Medical Bld. (Contract Zone)

Re: Request for Zone Change: 50 Sewall Street and Corner of Congress Street and
I-295 ramp
Response to Planning Board/ Staff Comments

A/E Project # 04052

In response to comments received from the Planning Board and planning staff, we provide the following information.

PROJECT: SEWALL STREET MEDICAL OFFICE BUILDING  
SHEET TITLE: SITE PLAN  
CLIENT: OLYMPIA EQUITY INVESTORS II, LLC

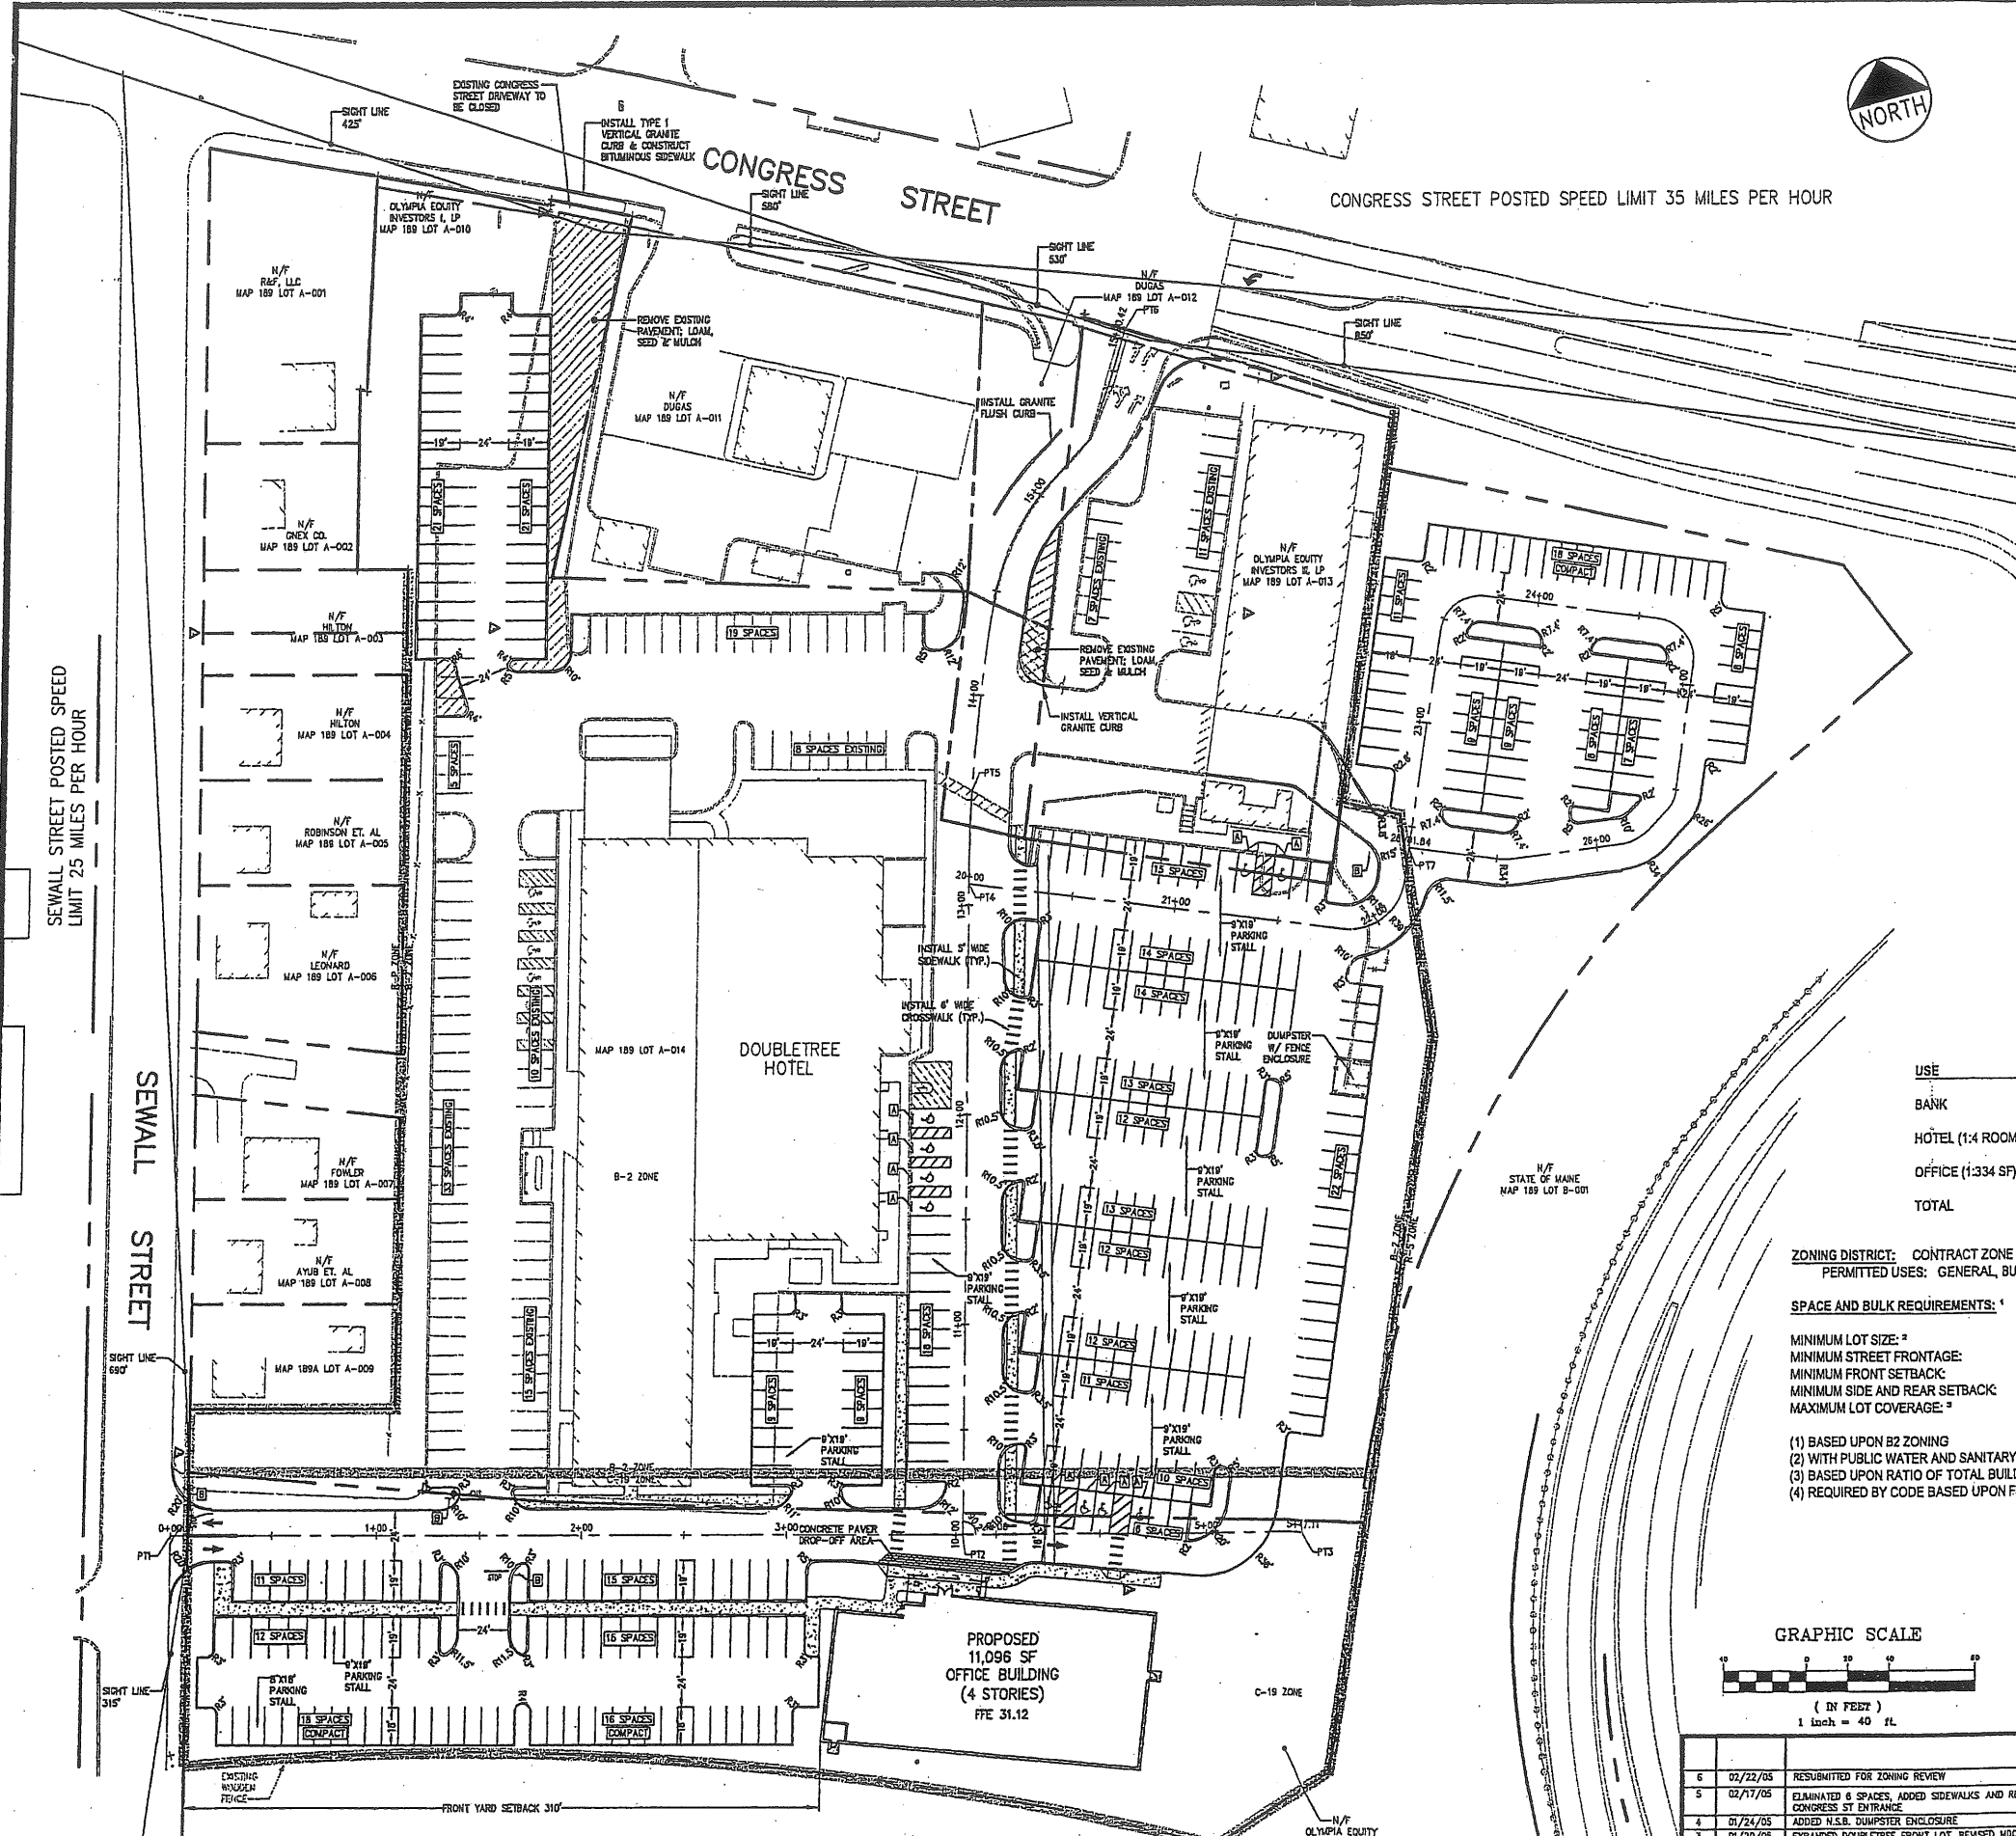
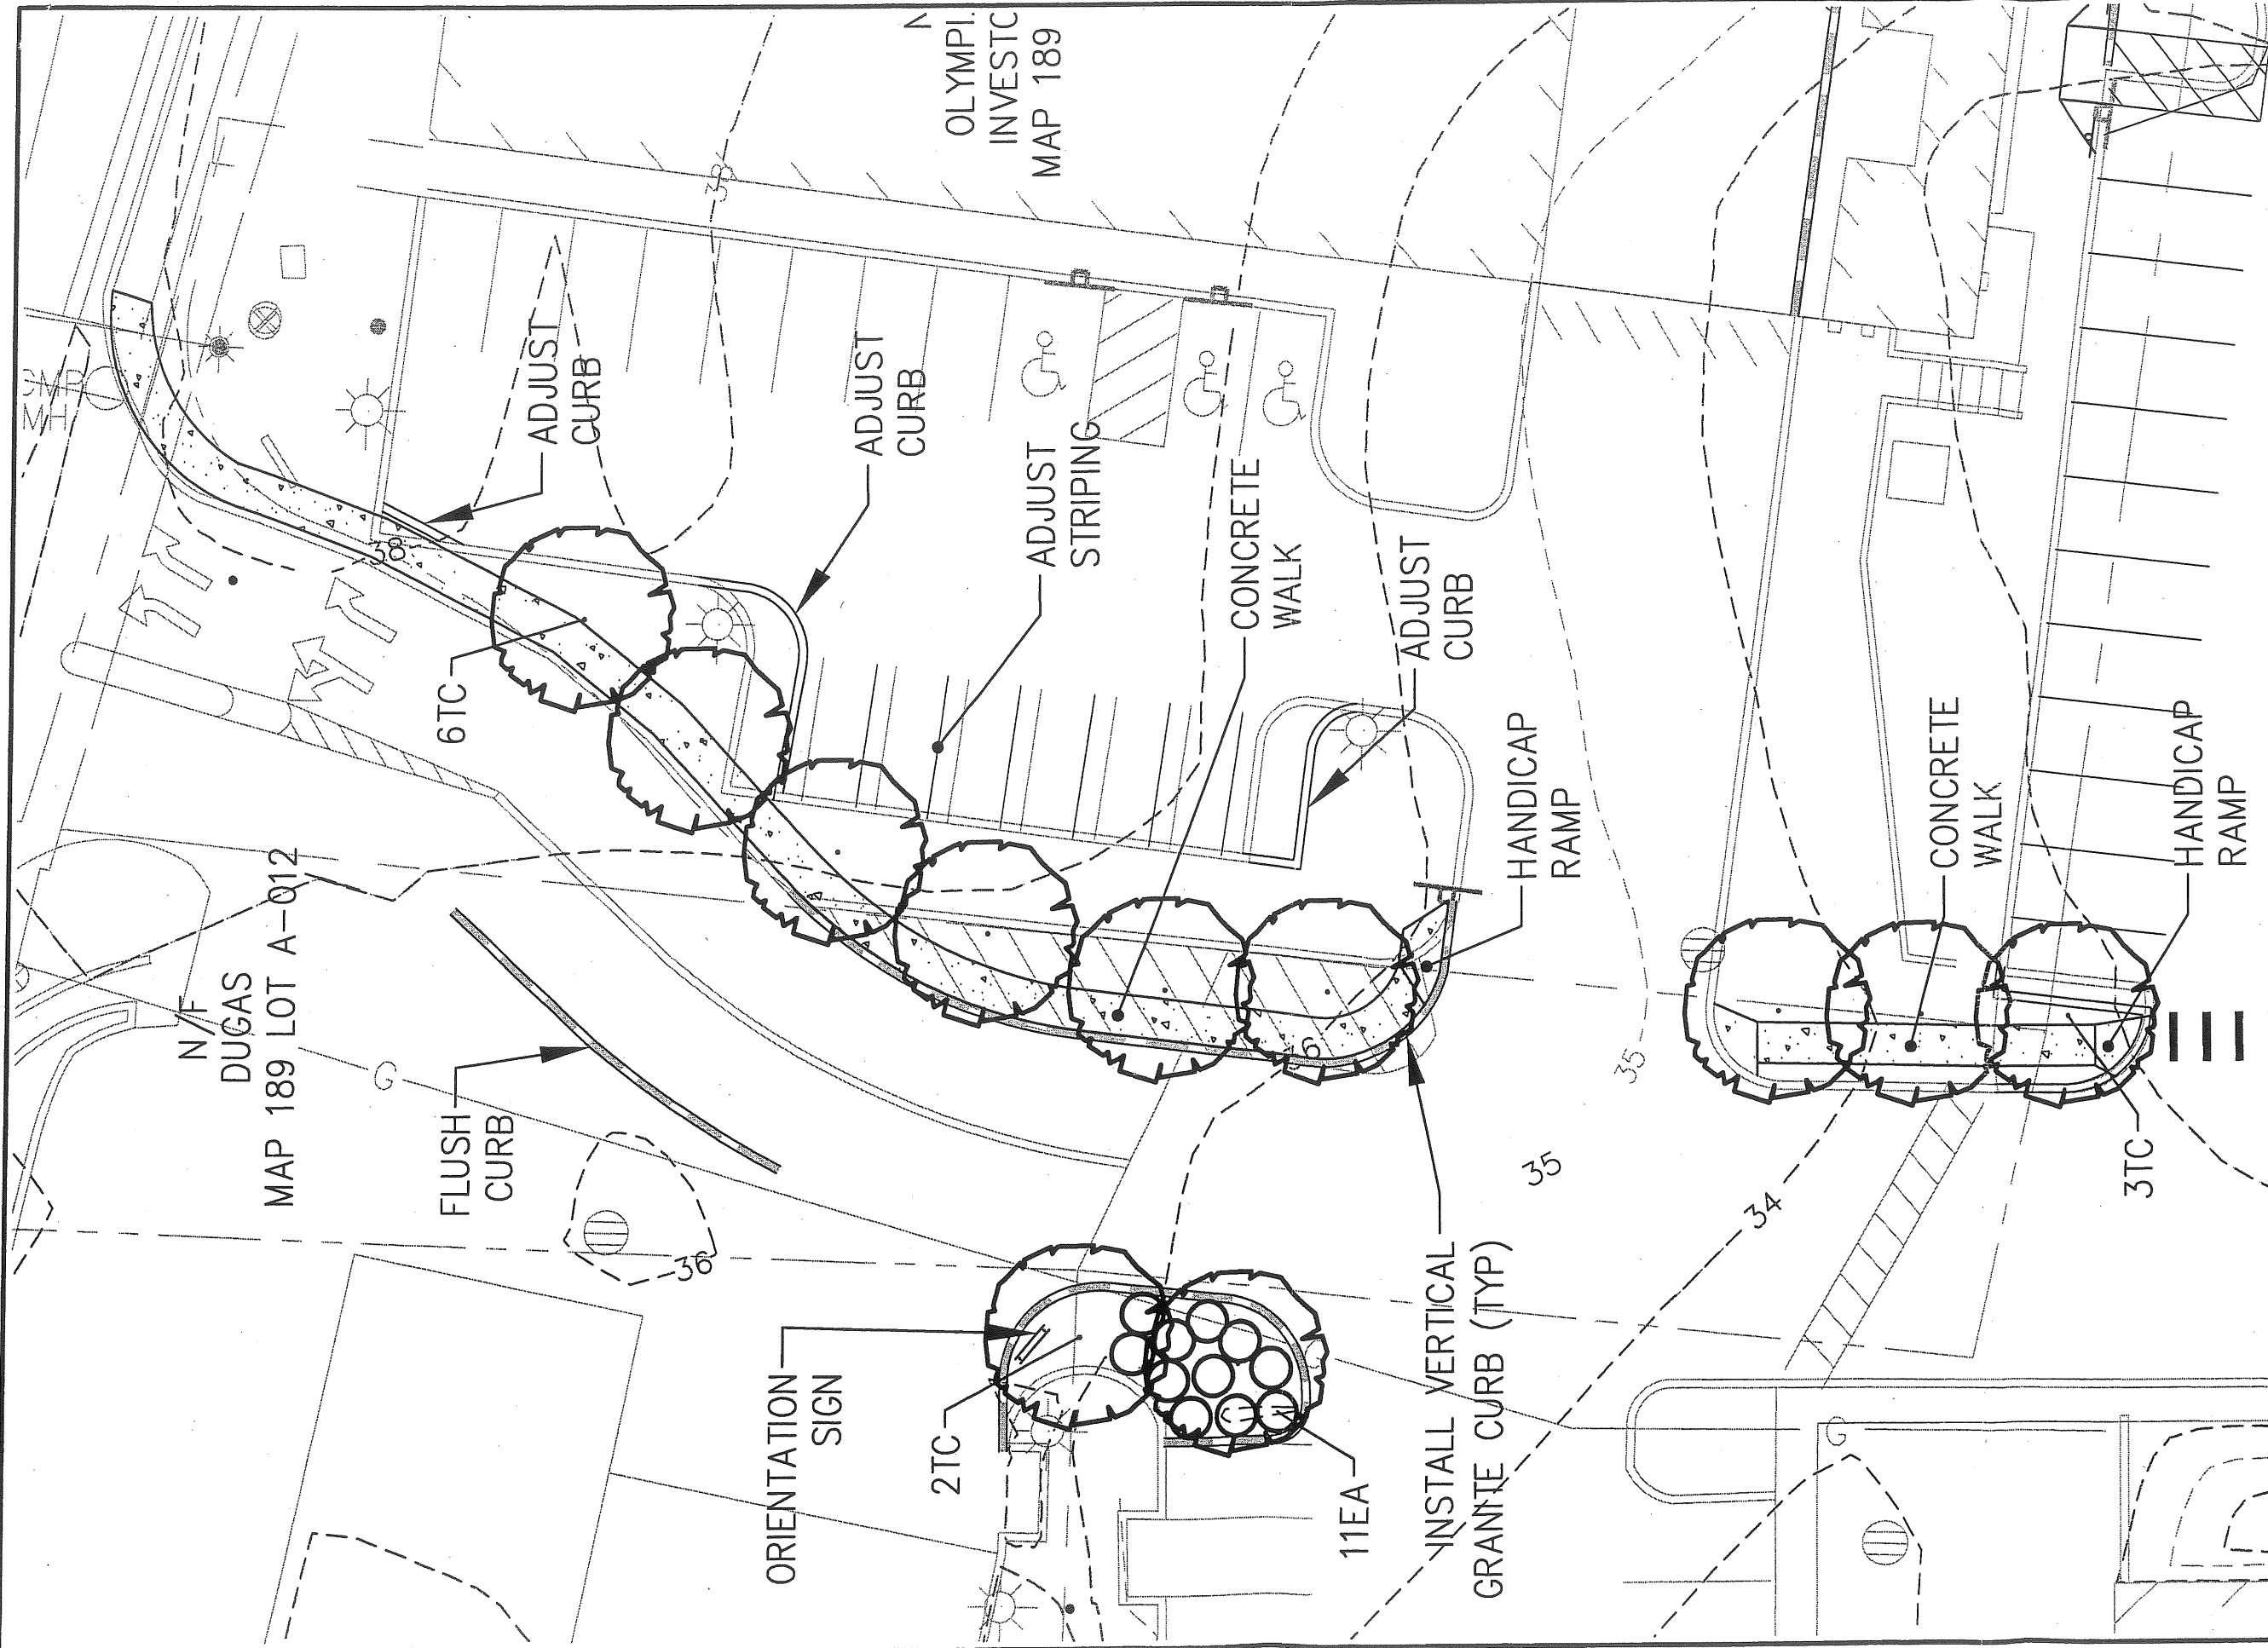
Comment: The entry drive alignment at Congress Street and the lack of a defined drive between the entry area and the Mobil Station is a concern.

Response: In 1999, as a condition of the site plan approval for the construction of a building on Lot A-013, Map 189 (the Coastal Savings Bank building), the entrance to the site from Congress Street was moved approximately 60' to the east in order to align with Massachusetts Avenue. This work also included a widening of Congress Street, \$165,000 of which was paid for by the applicant (Olympia Equity Investors III, LLC). In addition, as part of its approval of the site plan for the project the Planning Board required the following to further address traffic concerns, including

traffic concerns relating to the access drive shared by Mobil, the Doubletree Hotel, and the bank property: (1) the applicant was required to acquire land for the widening of Congress Street in this location, and to contribute the land to the City at no cost to the City; (2) the final engineering plans for the widening project had to be approved by the City's traffic engineer and MDOT; and (3) the applicant was required to install a traffic signal at the corner of Massachusetts Avenue and Congress Street.

Thus, Olympia understood that the work performed in 1999 would satisfy the traffic concerns previously presented by the access to the site. The current alignment is safe from a pedestrian and vehicular standpoint, and is in compliance with the 1999 site plan approval.
